Addendum No. 1

RE: Contract ID C203462

US-301 From I-95 To The Cape Fear River Project, and US-401 From Bridge Over SR-3828 To Ramsey Street

PROJECT NO.	SHEET NO.	TOTAL NO.
6CR.10261.79	7	8

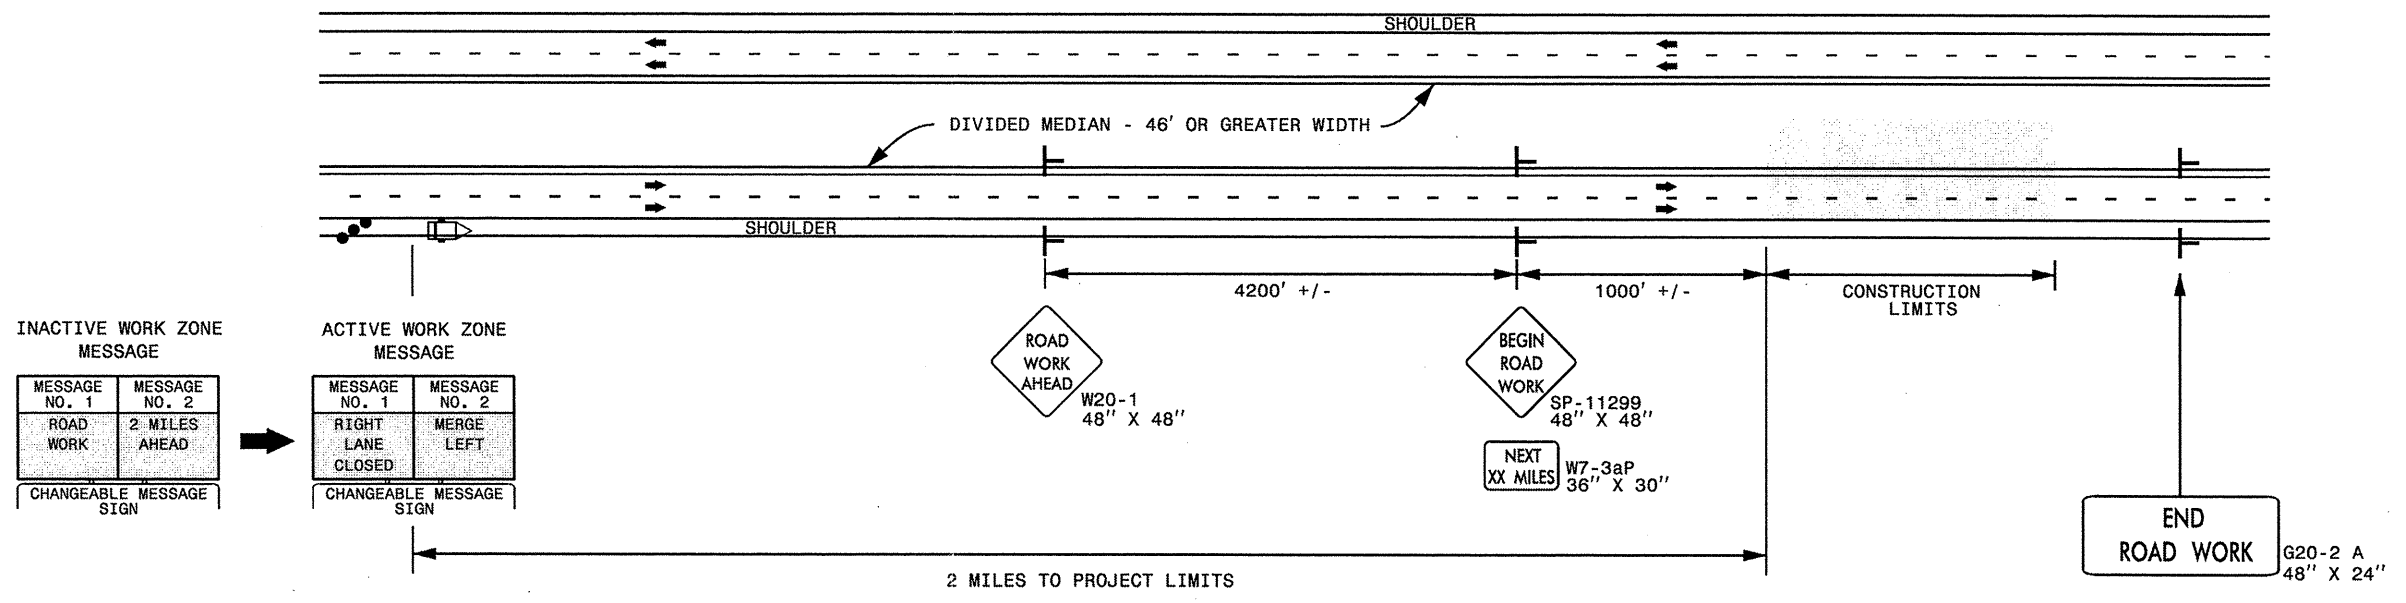
Sheet No. 7 has been revised to reflect the below noted pay item addition. Please void Sheet No. 7 in your plans and staple the revised Sheet No. 7 thereto.

On the item sheets the following pay item has been added:

<u>Item</u>	<u>Description</u>	<u>Old Quantity</u>	<u>New Quantity</u>
29-1245000000-E-SP	Shoulder Reconstruction	NEW ITEM	3.93 SMI
